March 9, 2020

El Paso County
Planning and Community Development
Nina Ruiz
2880 International Circle, Suite 110
Colorado Springs, CO 80910

The Copart comment letter dated September 11, 2019 and subsequent referral documents from the referral period are responded to in the following document. Comments are included as bold italicized font and responses in standard text.

SCREEN FENCE DETAIL
NOT TO SCALE

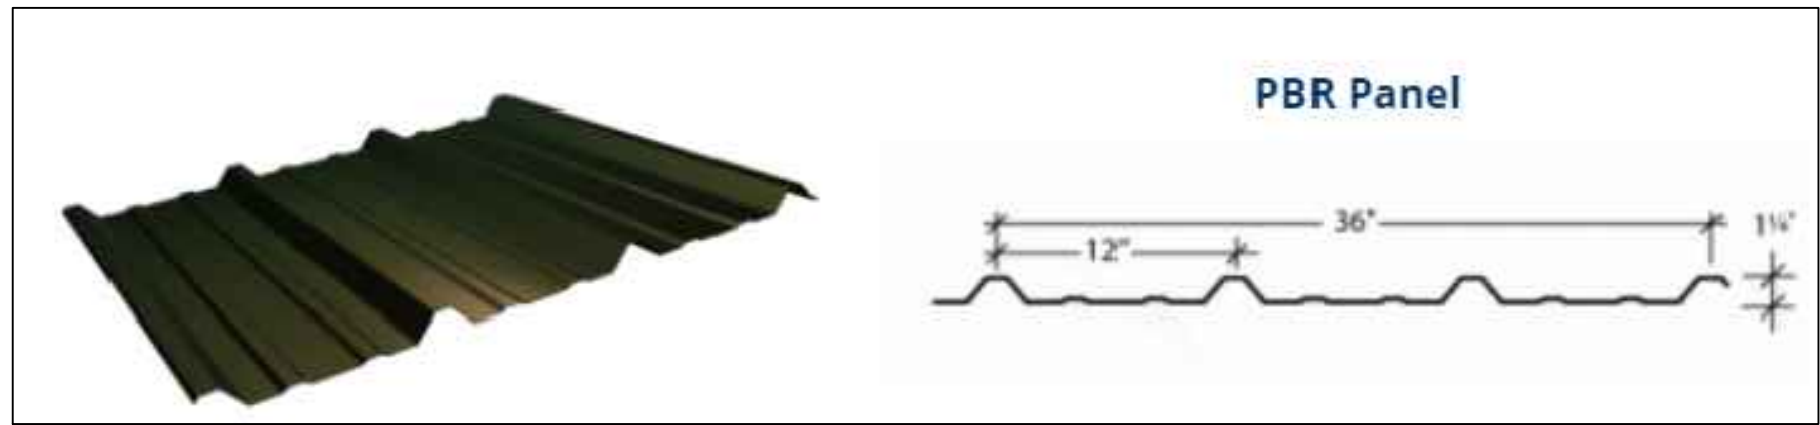
- ***Please provide a better graphic of what the fence will look like. A photograph of an example along with the fence detail may help staff determine if the fencing will be compatible with the surrounding area.***

Response: A photograph of the fence material as well as an additional detail of the fence have been added to the landscape plan.

LANDSCAPE PLAN

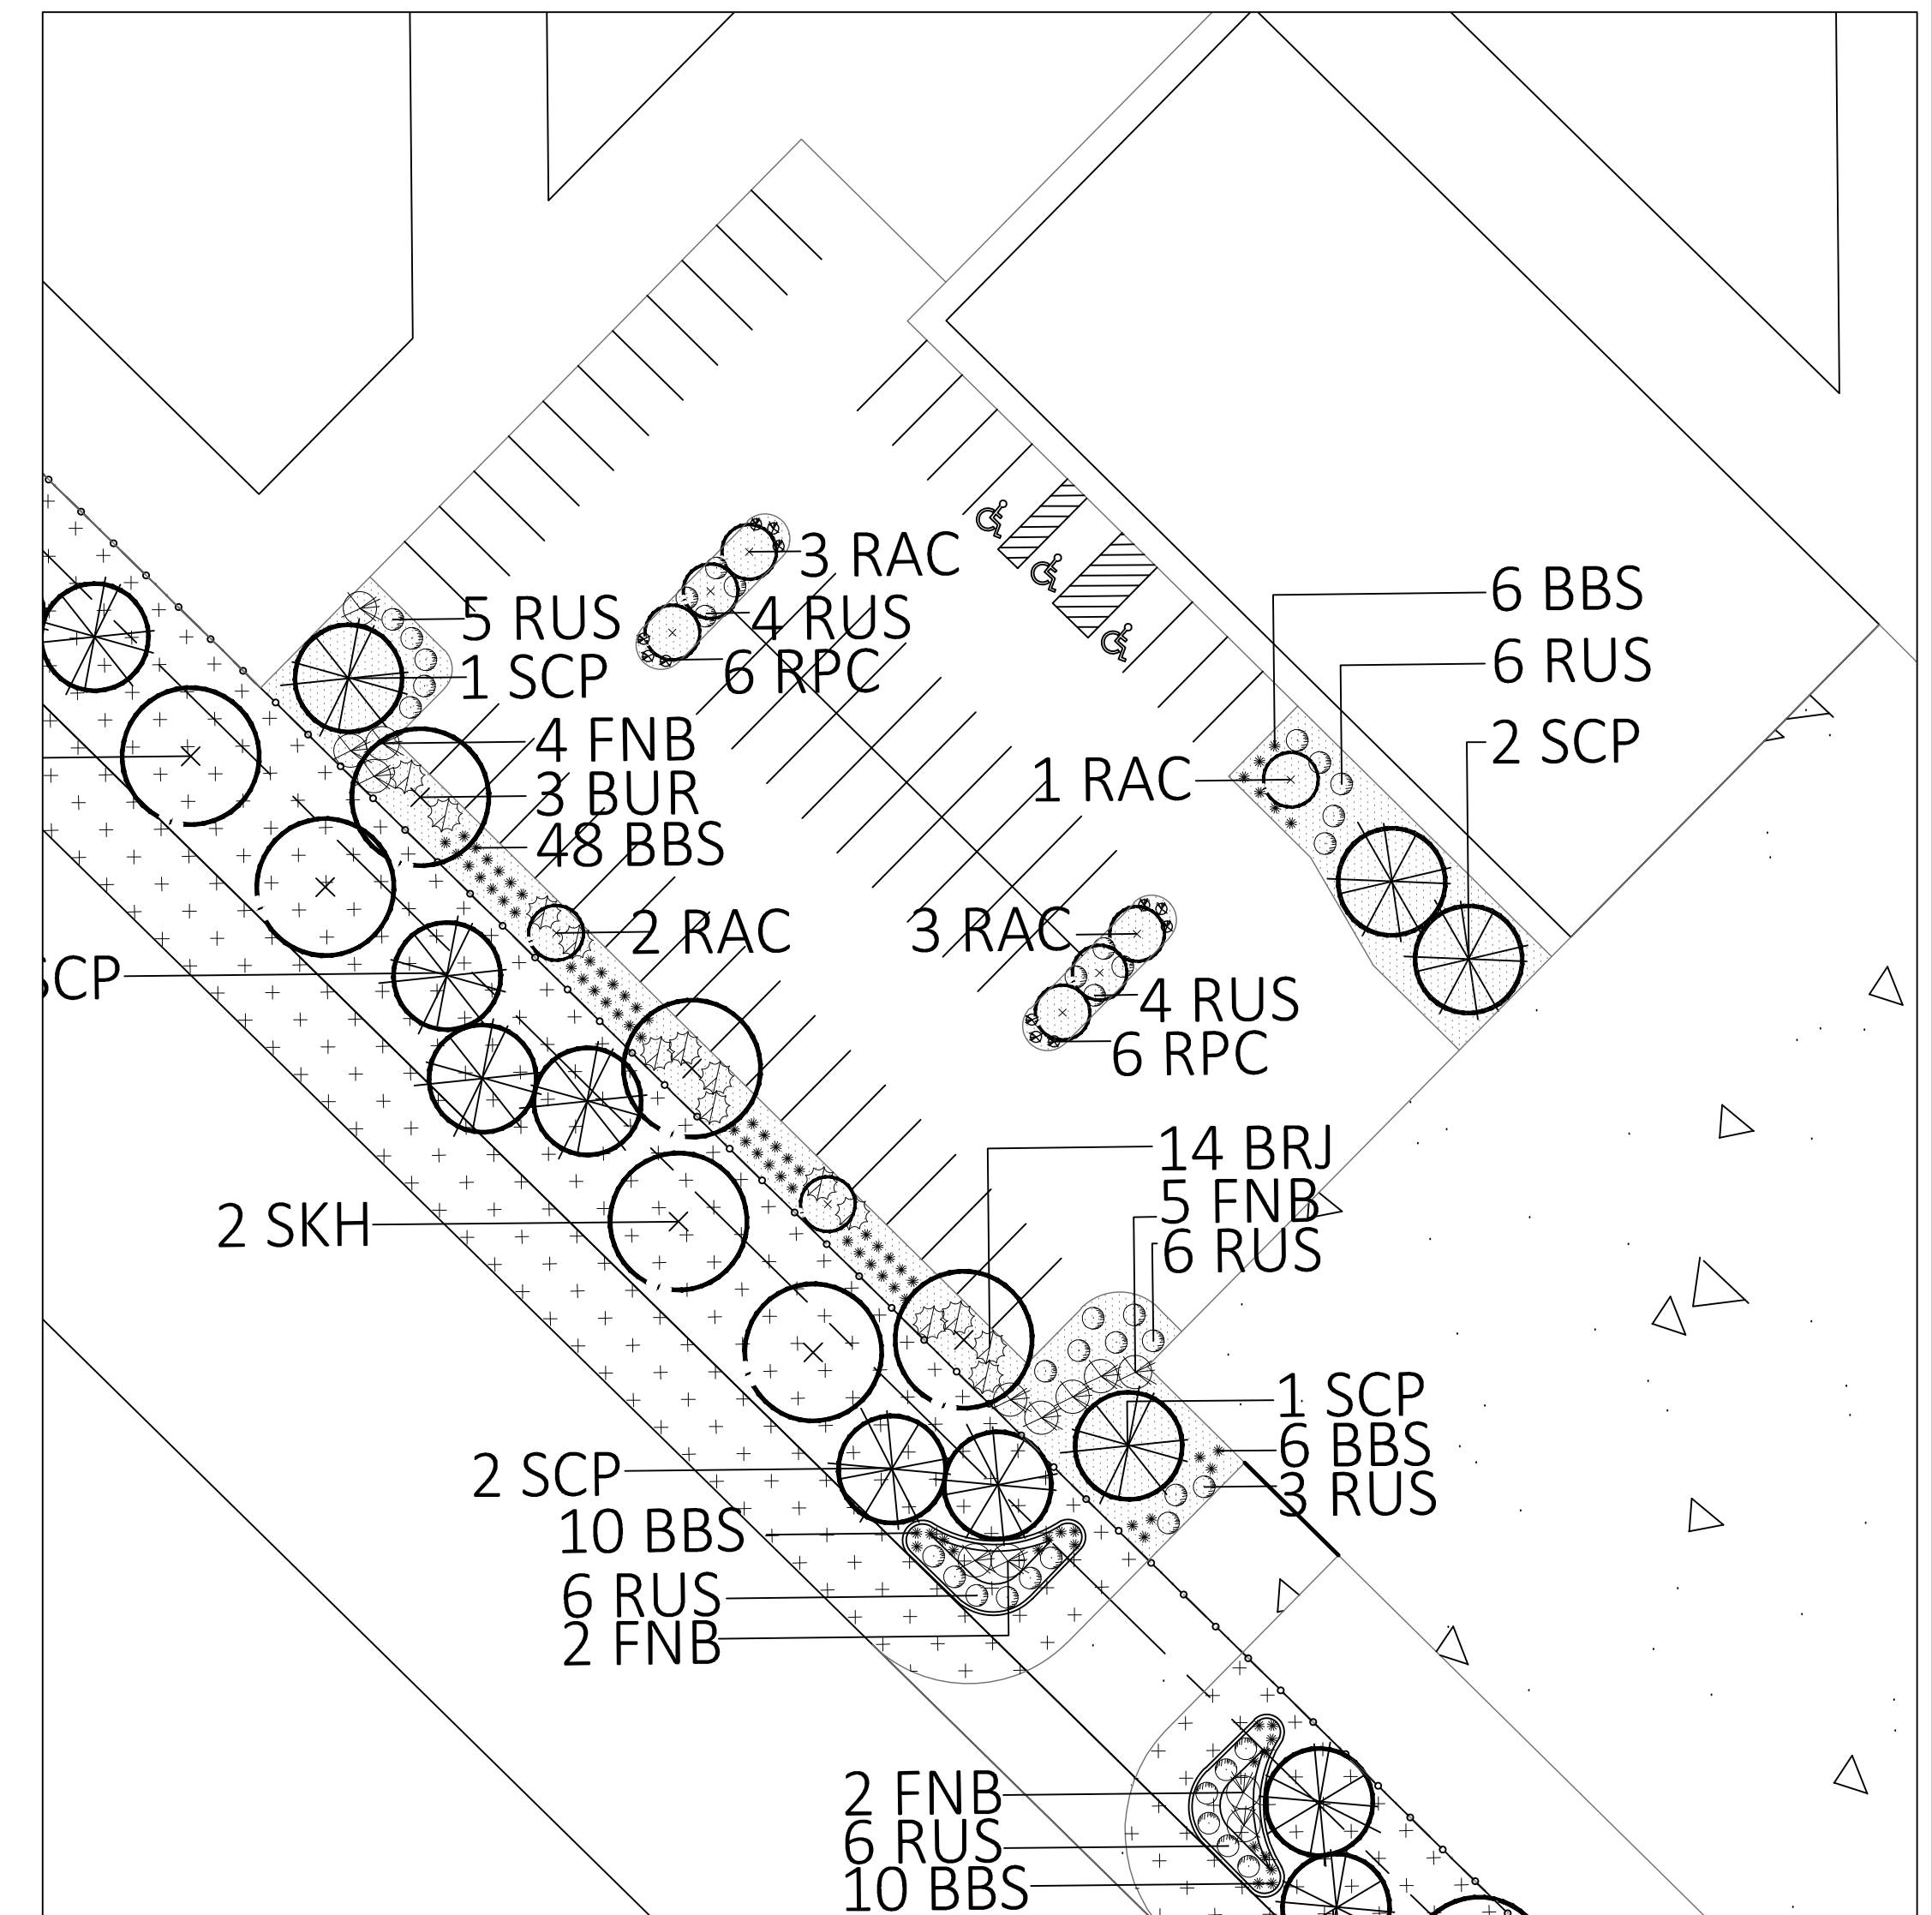
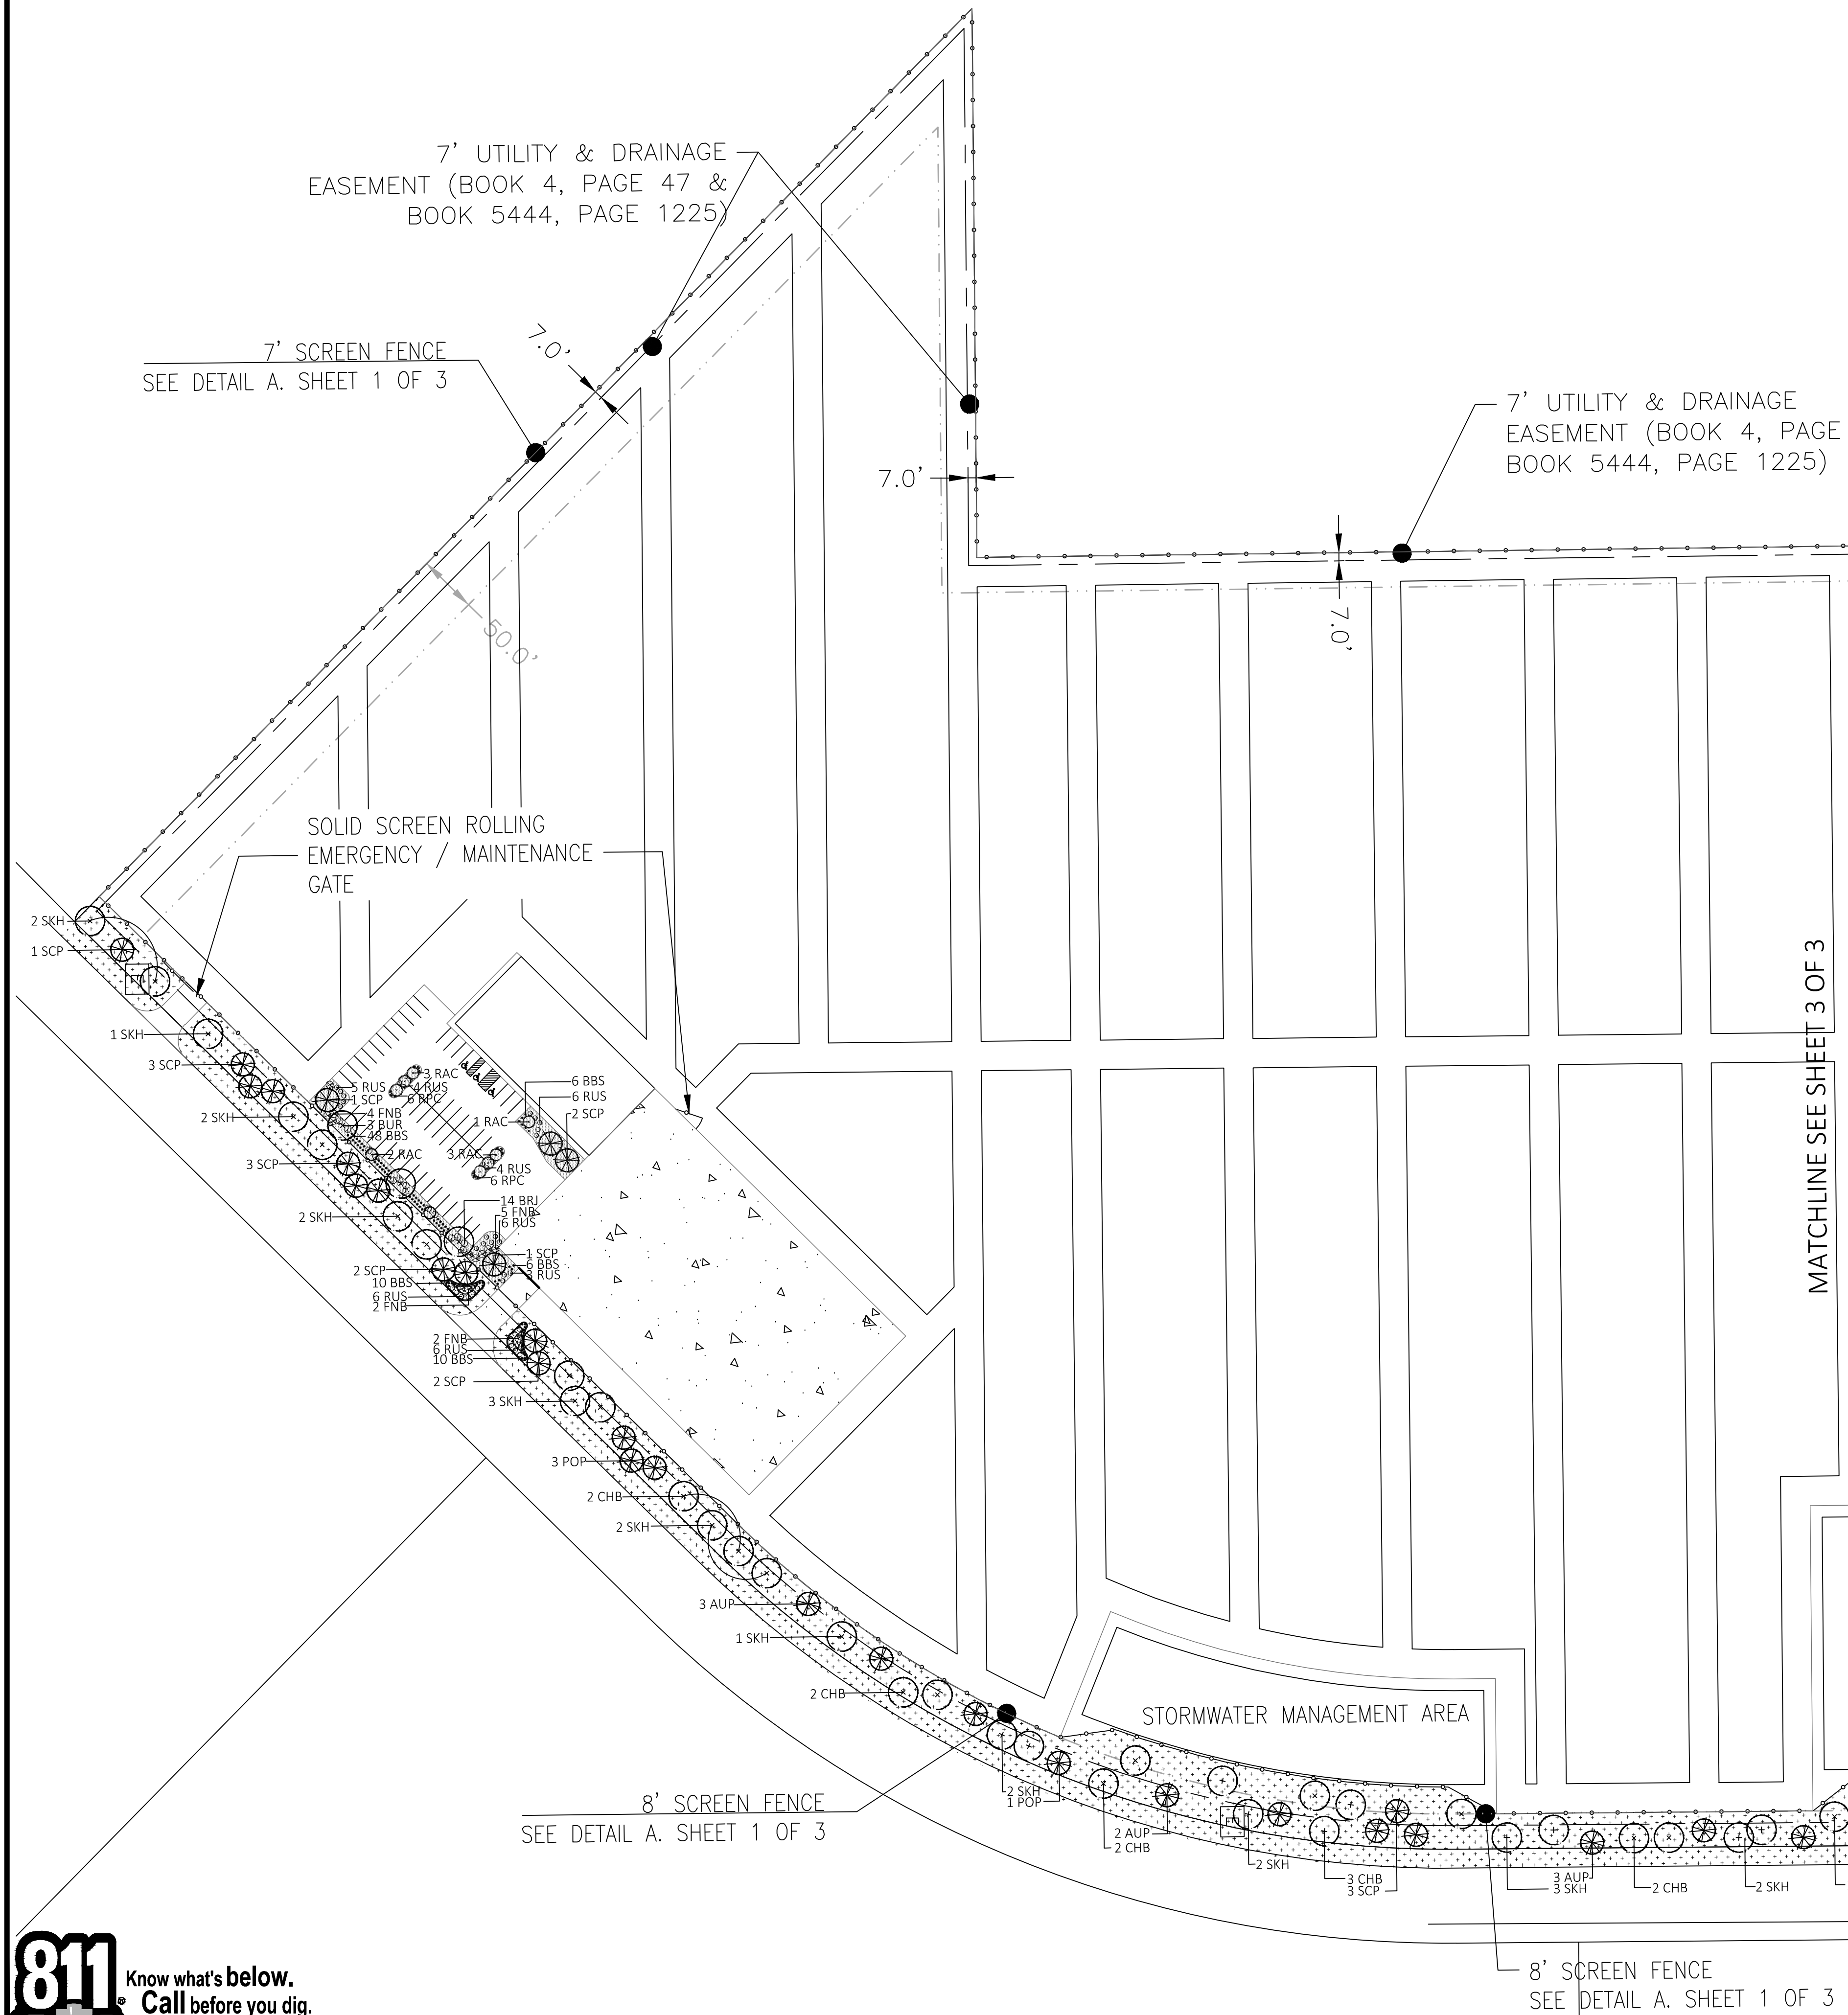
- ***Your landscaping plan shows that you will be providing less landscaping than what is required. Section 6.2.2 allows the PCD Director to approve an alternative landscape plan. The PCD Director will not be supportive of an alternative landscaping plan that decreases the amount of landscaping required. As discussed at the EA, mitigation and screening will be a critical component in the review of this proposal. As discussed in the EA, staff recommends that the applicant provide more screening than what the LDC requires in Chapter 6 for permitted uses. Staff does not feel as though the proposed screening adequately addresses the potential visual/glare impacts from the large 80-acre storage area on surrounding properties due to there being a gentle slope to the parcel.***

Response: Acknowledged, landscape plan has been updated to meet the required tree amount, see Landscape Plan. To address the glare impacts from the site, Copart conducted an in house glare study for the project site and additional graphics have been created to address the effects of the glare, the direction in which the glare will be directed, and how much of the site you will see from the areas of concern. From these studies, the orientation of the vehicles within the site will be directed North/South to minimize the glare effects to the East. These graphics are uploaded with the submittal.

VICINITY MAP

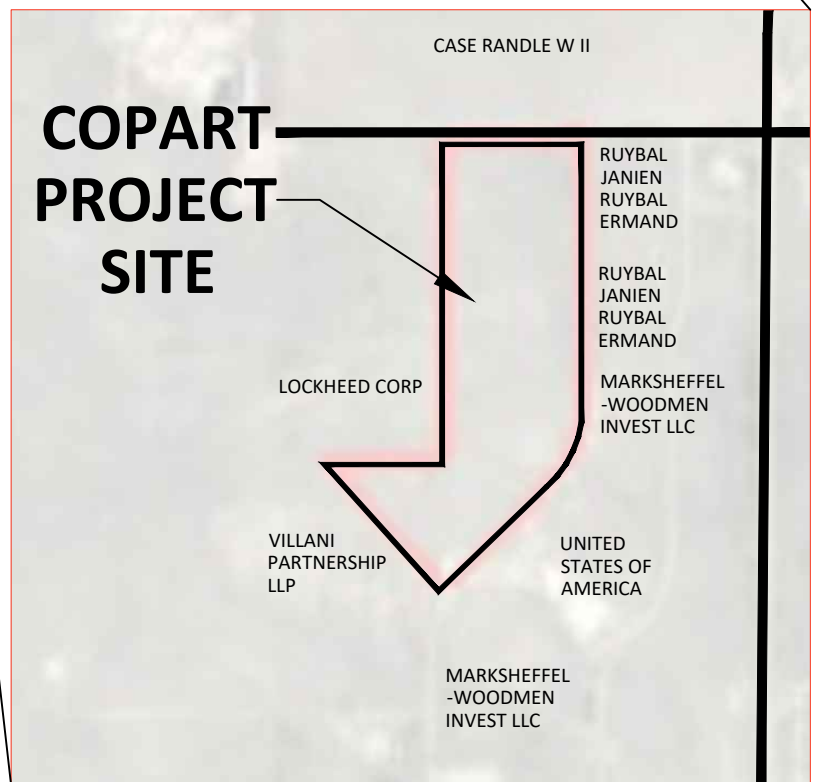
- ***The vicinity map does not show a major intersection in relation to the subject parcel. Please zoom out a bit to show a broader extent.***

Response: Acknowledged, Vicinity map has been updated to show major roadways.
